From: Amy Myer <Amy.Myer@arun.gov.uk>
Sent: 23 December 2020 13:28
To: Planning.Responses <Planning.Responses@arun.gov.uk>
Cc: Daniel Vick <Daniel.Vick@arun.gov.uk>
Subject: FW: Y/126/20/DOC - Land East of North End Road - UPDATE AND REQUEST FOR EXTENSION OF TIME 27th Jan 2021

Subject: Y/126/20/DOC - Land East of North End Road - UPDATE AND REQUEST FOR EXTENSION OF TIME

I have now had chance to fully review all the conditions and information submitted within this DOC application. There are outstanding matters with a number of these (as set out below) which will prevent us from being able to discharge them at this time, and rather than refuse them, we wanted to offer you the opportunity to provide some revised information and an Extension of Time to resolve these matters.

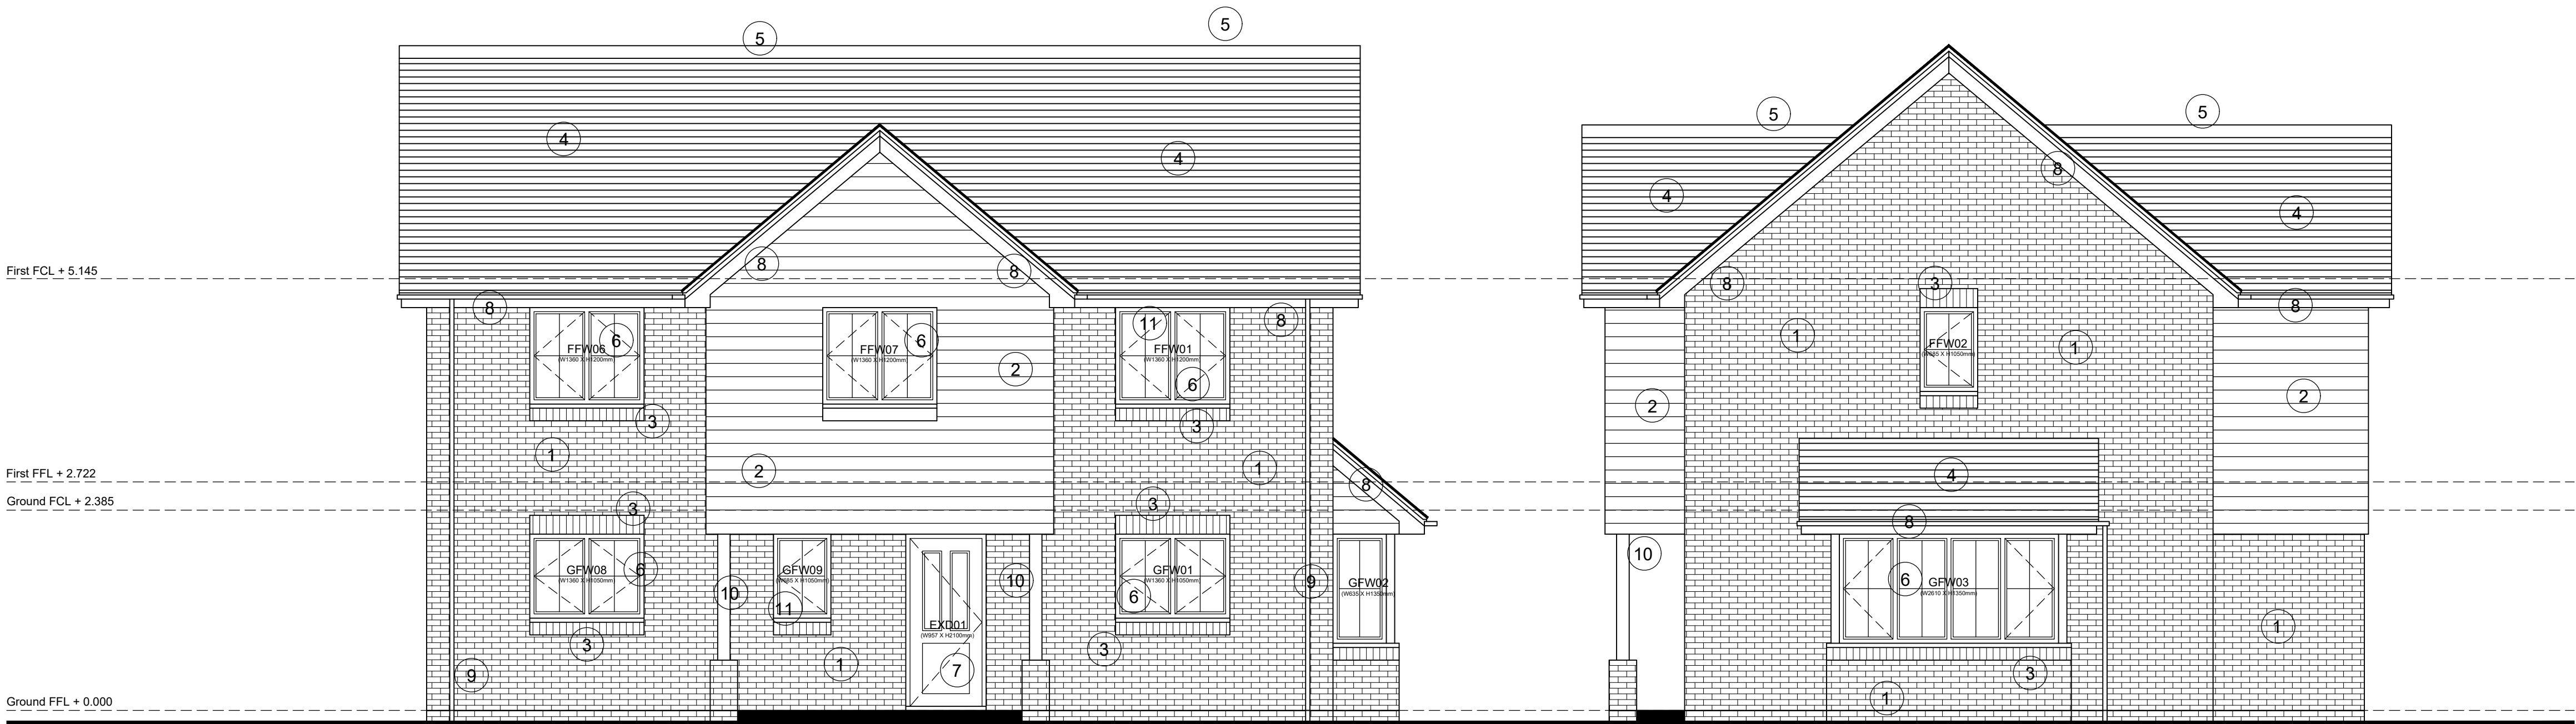
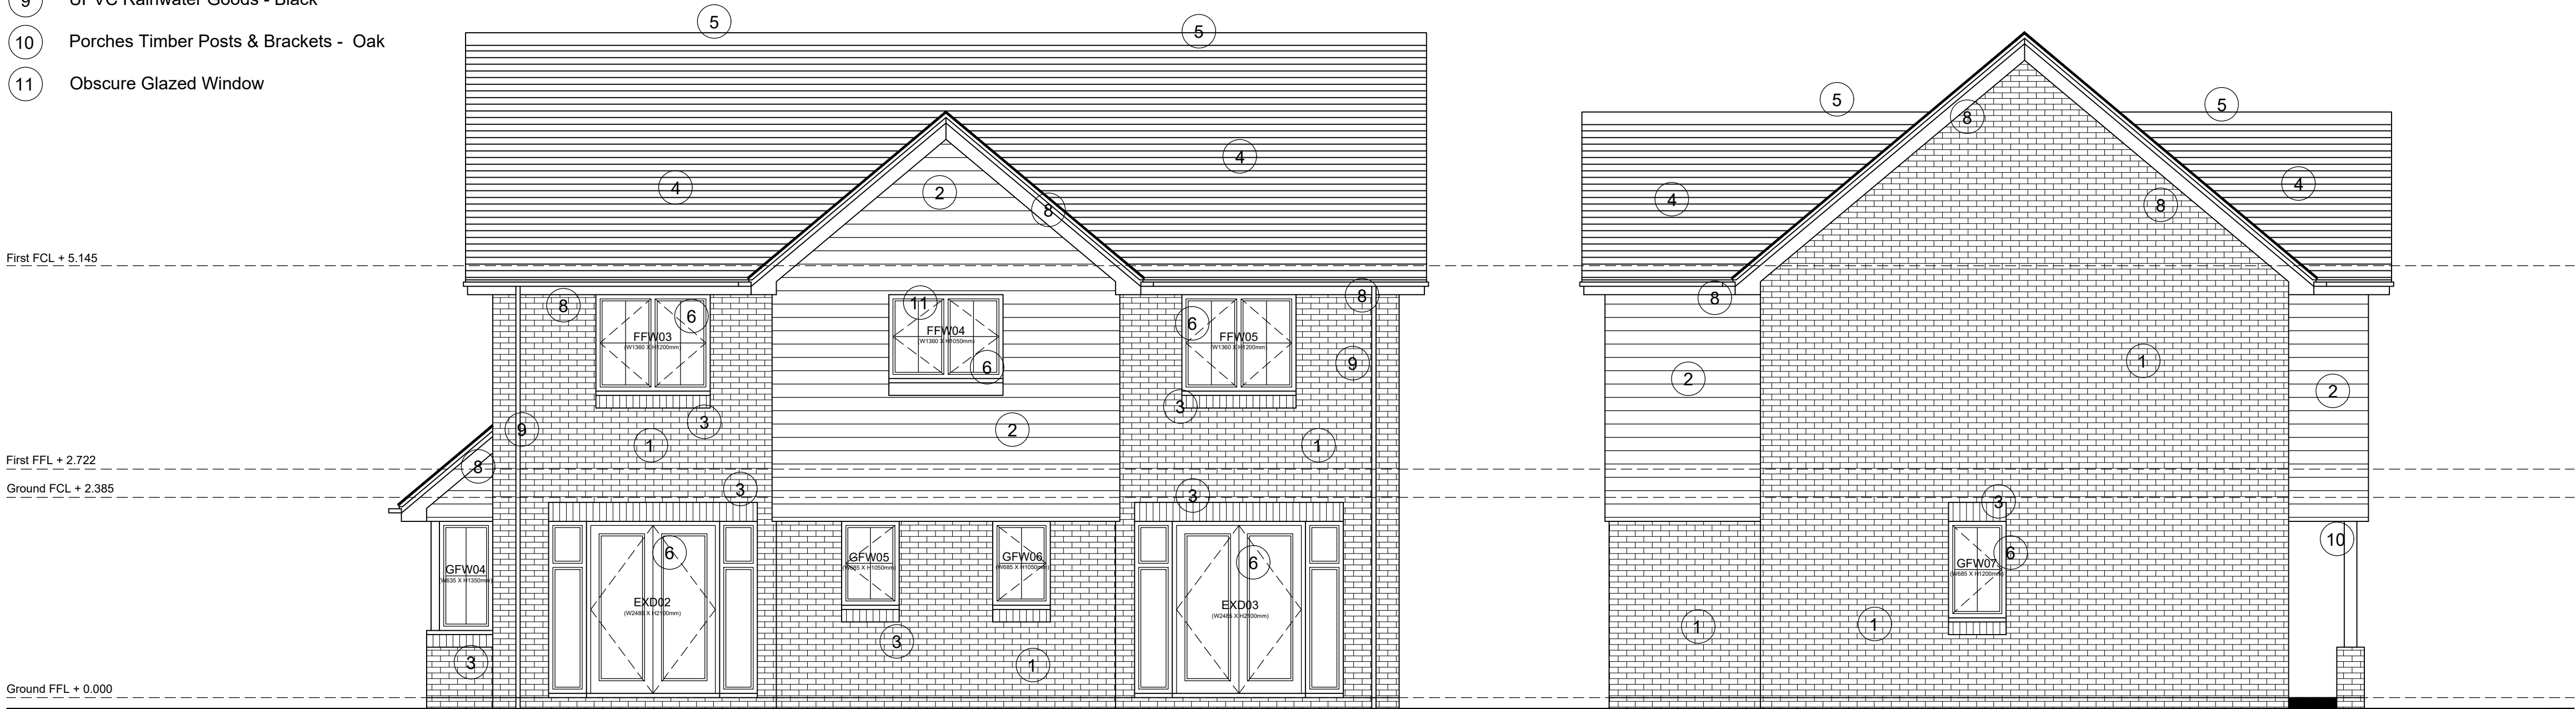
Condition 12 – materials – the proposed elevations specifying the materials are different from the approved elevations in both design and materials shown (e.g. fenestration/gable end detailing shown and flint indicated etc.). These elevations need to match to be approved, since the acceptability of the scheme depended on the design and materials proposed at the time. The only thing that needs to be specified in the drawings at this stage for the DOC is the materials. You should also provide a document with images showing the spec of the materials. If you want to change the actual design or proposed materials indicated on the approved drawings, then this will need a separate appropriate consent.
